KIRKLEES METROPOLITAN COUNCIL INVESTMENT & REGENERATION SERVICE

DELEGATED DECISION TO DETERMINE PLANNING APPLICATIONS

Reference No:	2023/62/92245/E
Site Address:	adj, 2, Kenmore View, Cleckheaton, BD19 3EH
Description:	Erection of attached dwelling
Recommending Officer:	Edward Cheseldine

Officer Report

**TITLE**  
PROPOSED ELEVATIONS

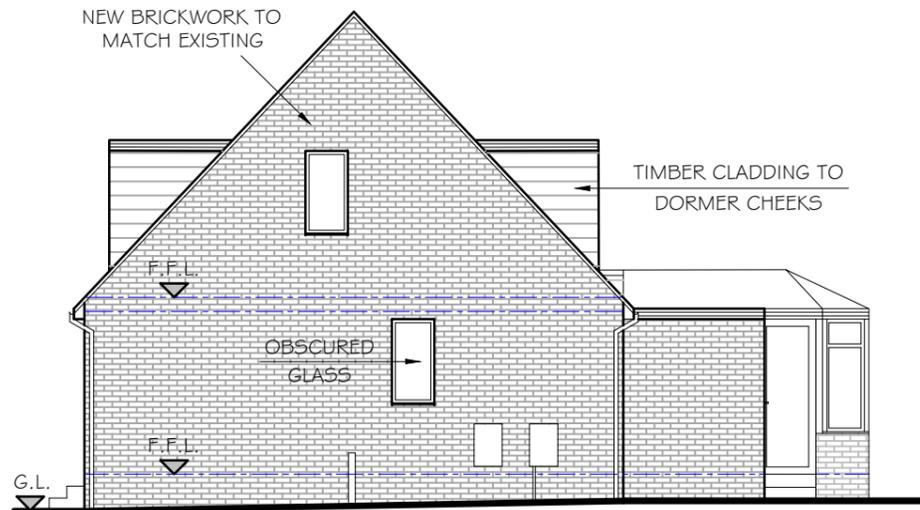
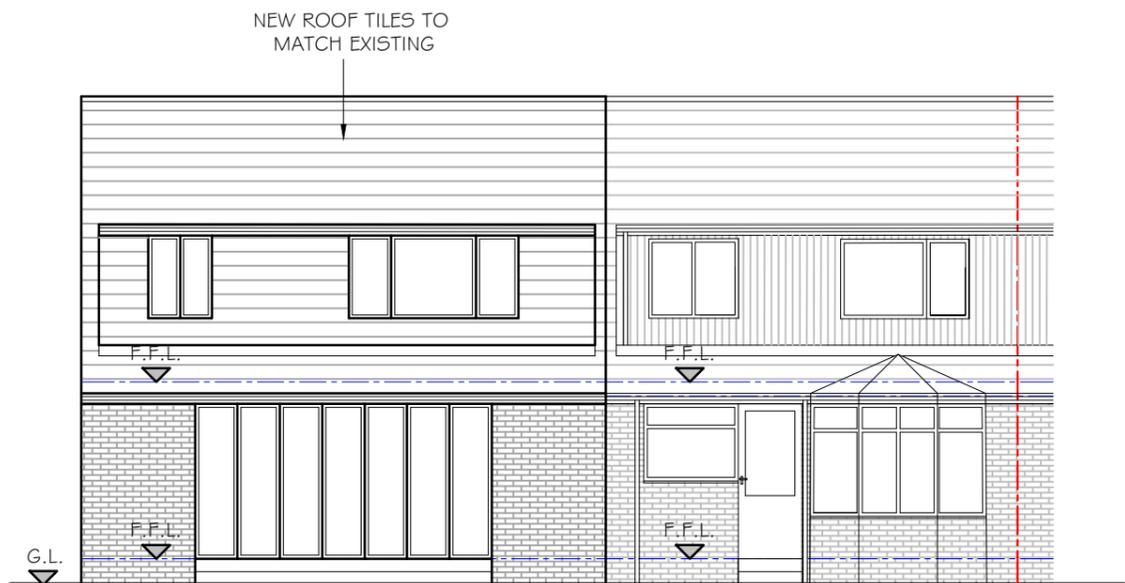
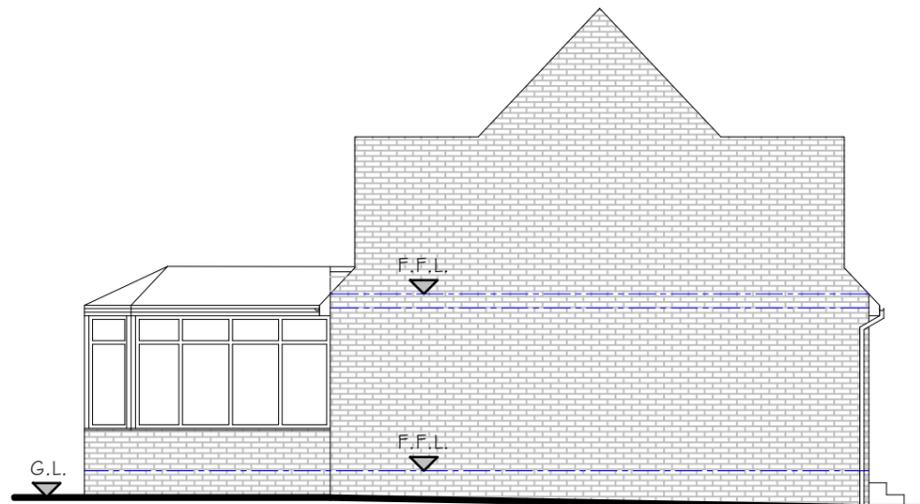
Moving on to appearance, dwellings on Kenmore View are constructed predominantly of brick exterior walls with concrete roof tiles. Dormers are mainly wooden with some in Upvc. The application proposes brick exterior walls, concrete roof tiles and a wood panelled dormer which will marry up with materials present on the street, as well as the adjoining property. The pitched roof style will continue the form and shape of the terrace row.

The front elevation facing Kenmore View features a simple design with well placed openings and doors that resemble the placement of the neighbouring dwelling. There are large openings on the rear ground floor elevation, these cannot be seen from the public domain and cause no material harm to the character of the host dwelling or surrounding area.

The roofline design not only relates well to the site contexts but continues the roofline of the terrace row.

3. Prior to construction of the dwelling hereby approved above slab level, details of all the external facing and roofing materials of the dwelling shall be submitted to and approved in writing by the Local Planning Authority. Thereafter the dwelling shall be carried out in accordance with the approved details and retained as such.

PROPOSED SITE PLAN

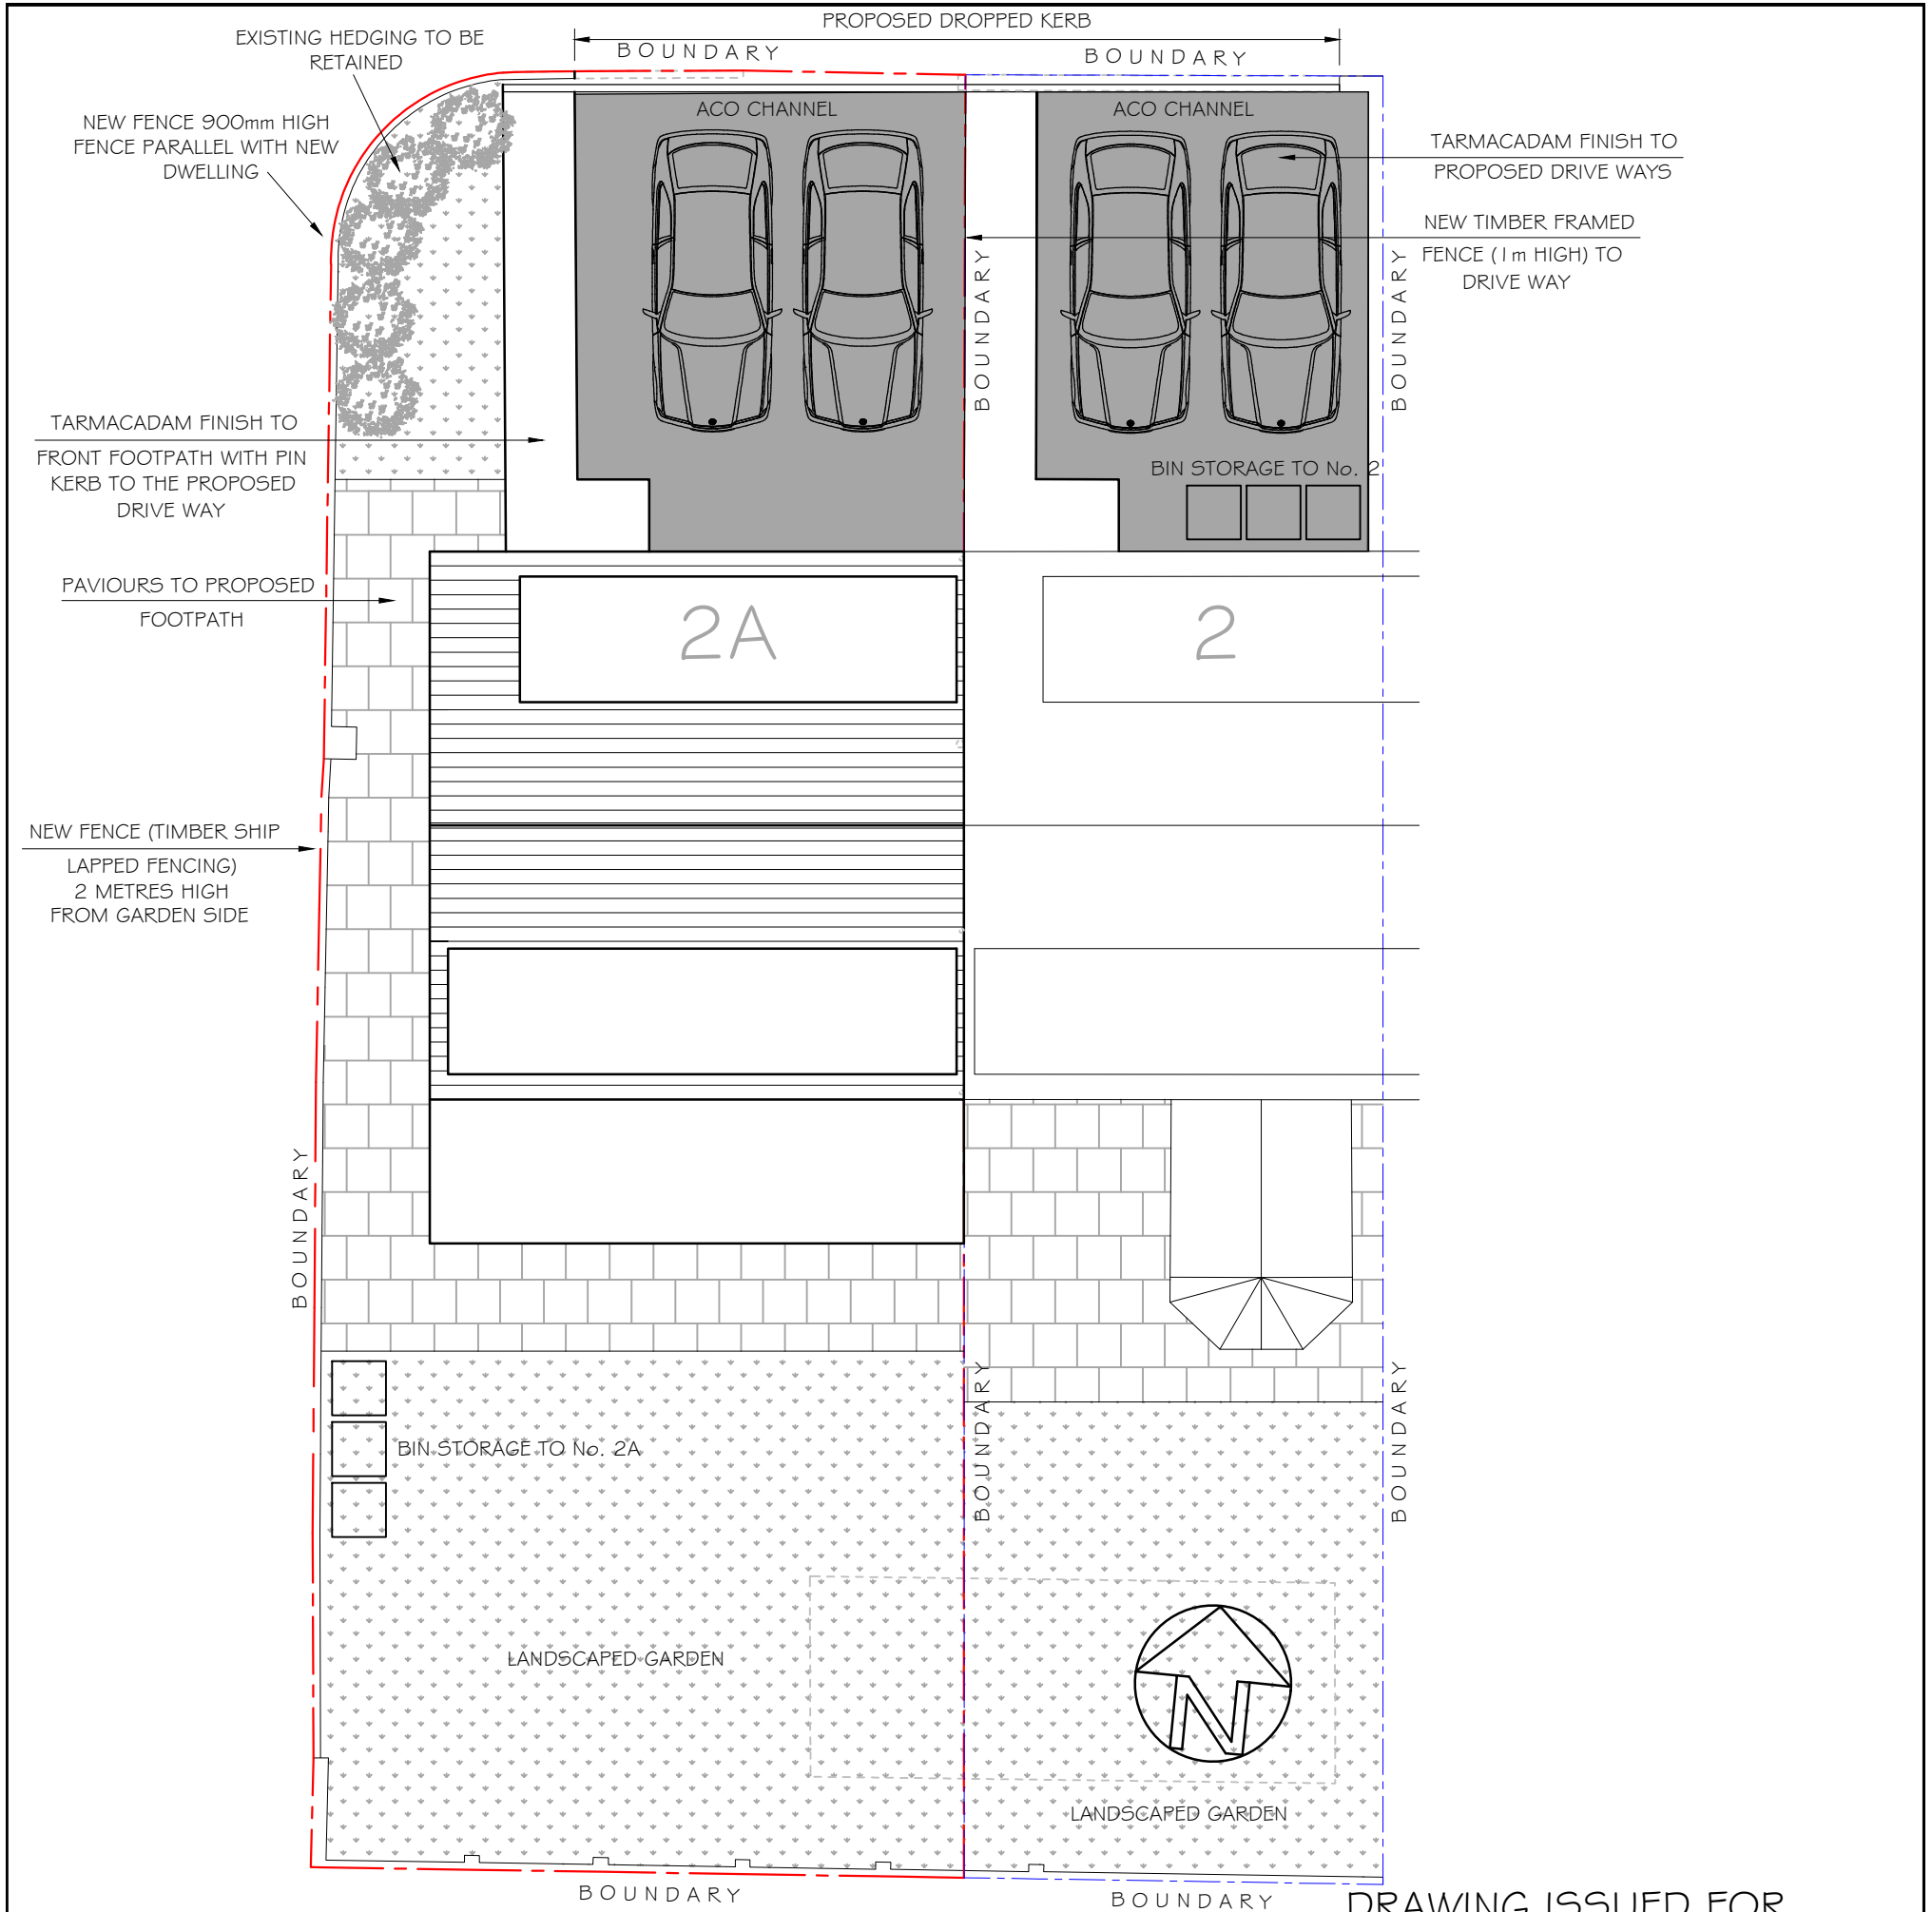
Amended plans were requested by the planning officer to retain soft landscaping elements to the front outdoor area of the site.

The development include parking to the front which replicates others within the street scene. An amended plan demonstrates some landscaping to be maintained which is considered, on balance, acceptable in this instance.

It is noted that a 2 metre high fence reducing to 900mm is proposed to the site boundary. It is unclear where the fence is reduced. In order to protect the amenity of the area within context of the site a condition requiring additional detail is imposed.

5. The dwelling hereby approved shall not be occupied until all areas indicated to be private drives on Drawing No. 23-019-03 Revision B are laid out with a hardened and drained surface in accordance with the Communities and Local Government; and Environment Agency's 'Guidance on the

13. Notwithstanding the submitted details, prior to the first occupation of the dwelling hereby approved, a hard landscaping scheme shall be submitted to and approved in writing by the Local Planning Authority and shall include:

- Details of boundary enclosures, including location, heights and materials; and
- Details of pavements, pedestrian accesses and steps.
